Planning Application No: 3/2024/0722

Proposal: Proposed dormer to front, two-storey extension to rear, demolition of existing garage and replacement with new single-storey single garage and garden store.

Location: 15 Highfield Drive Longridge PR3 3SN

PROPOSED SITE & FLOOR PLANS

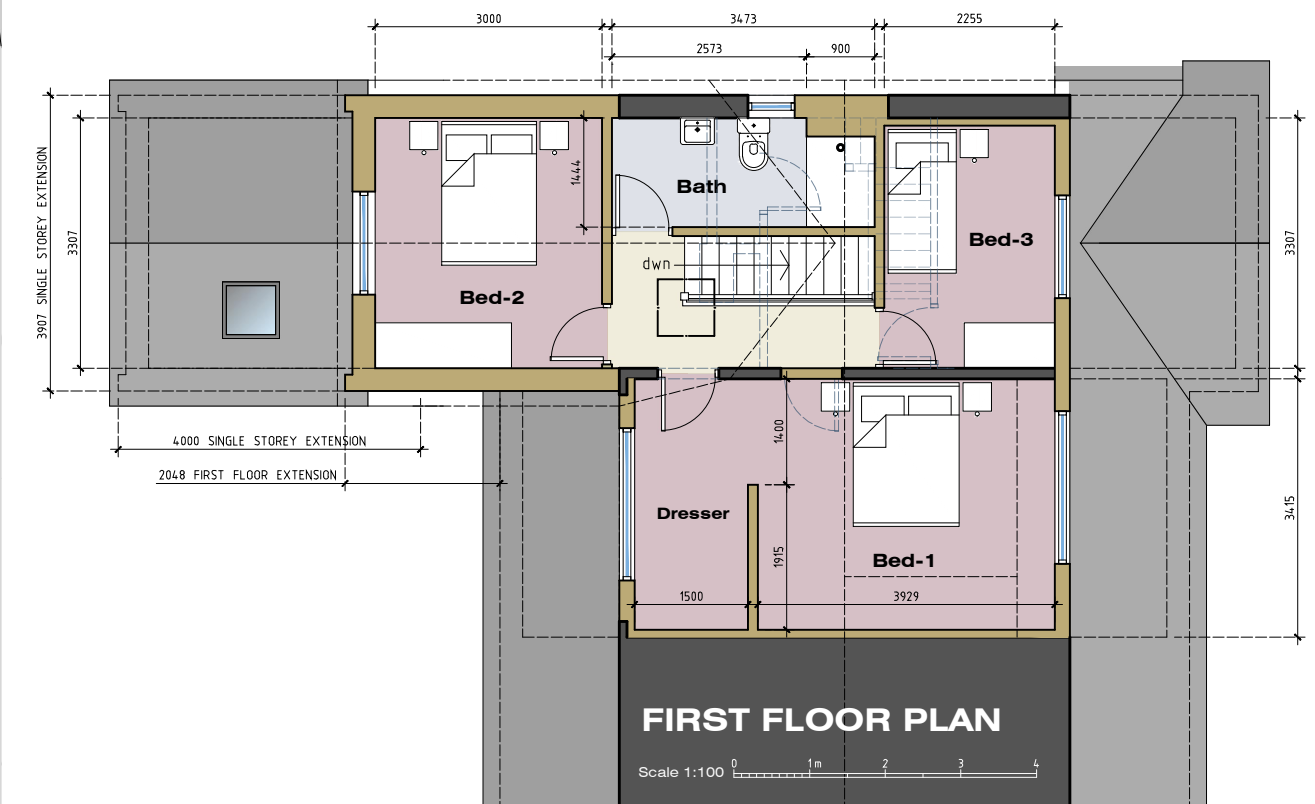
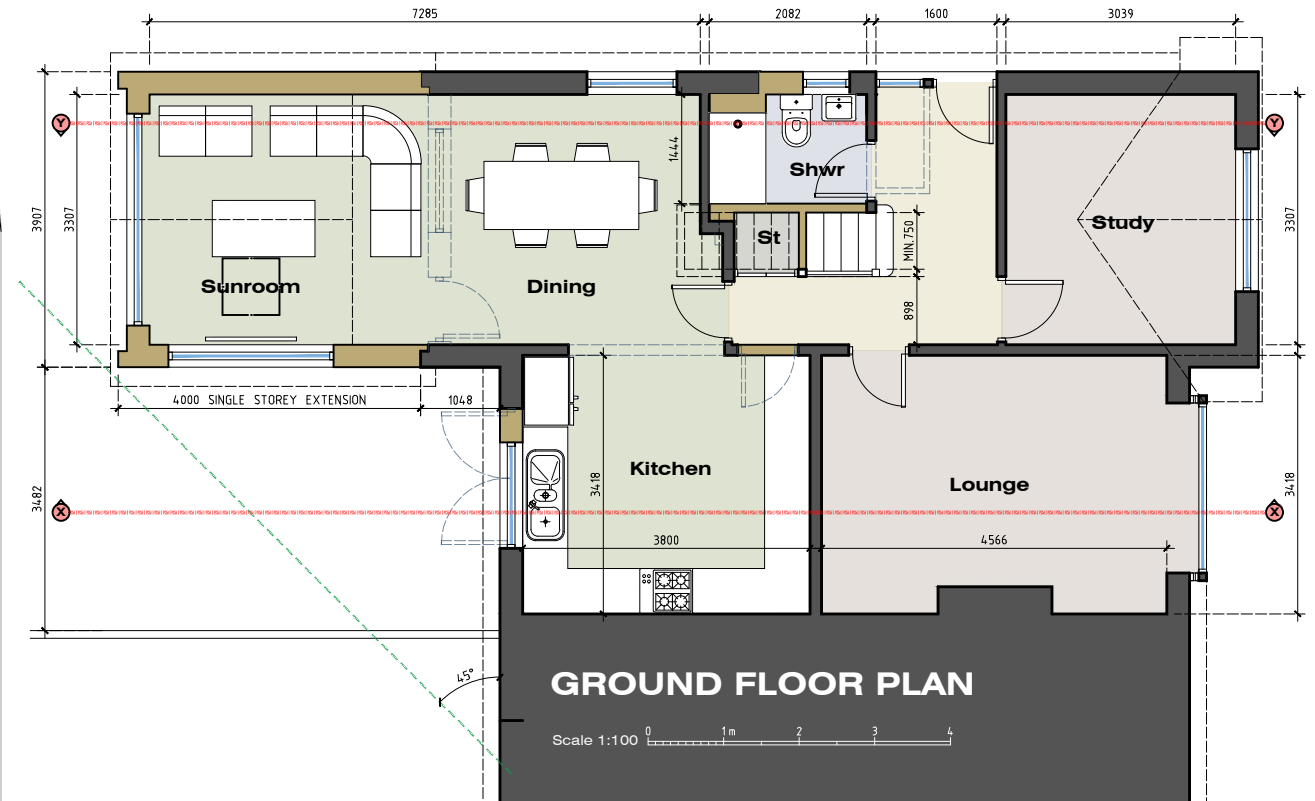
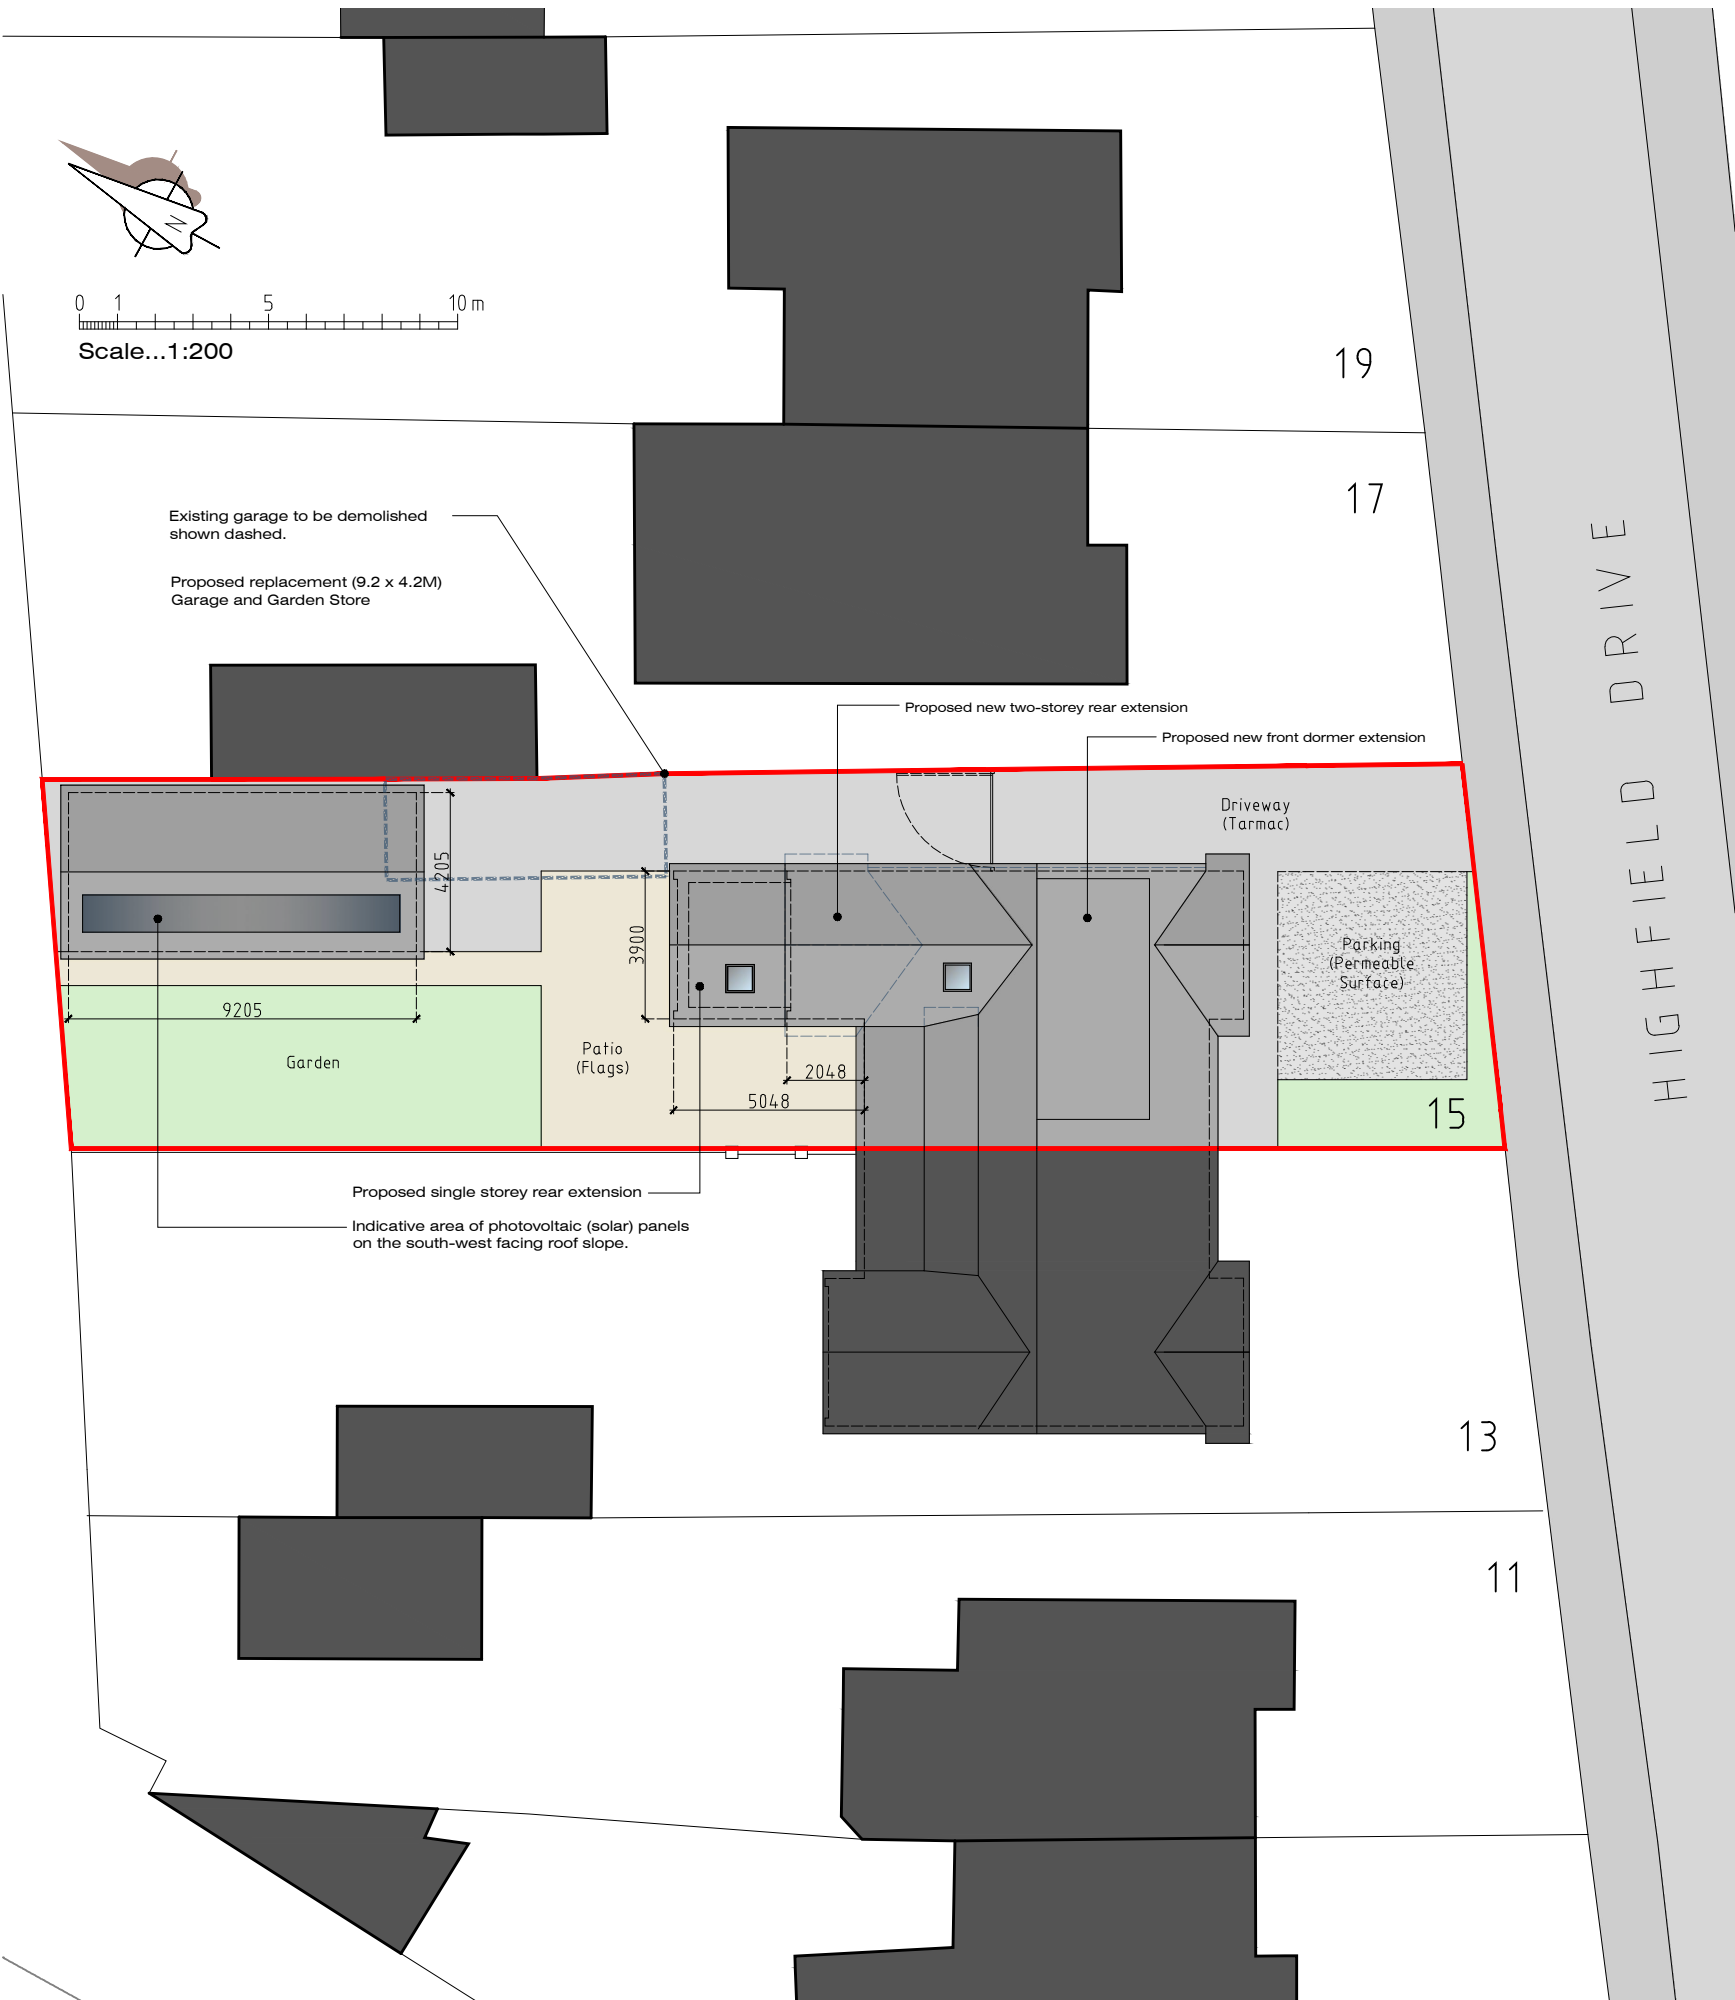
The proposal replaces an existing garage and there is a proposed increase in bedrooms from the current 2 to 3. A new parking space is proposed to the front of the property which will require the vehicular crossing to be extended to the full length of the drive in order to protect the footway from damage. There is no loss in on site parking therefore, there are no highway implications and no objection to the proposal subject to the following conditions.

- The parking areas must be constructed of a bound porous material and created before first occupation up until the lifetime of the dwelling existing in its proposed state. Reason: To ensure that satisfactory parking is provided before the dwelling hereby permitted becomes operative.
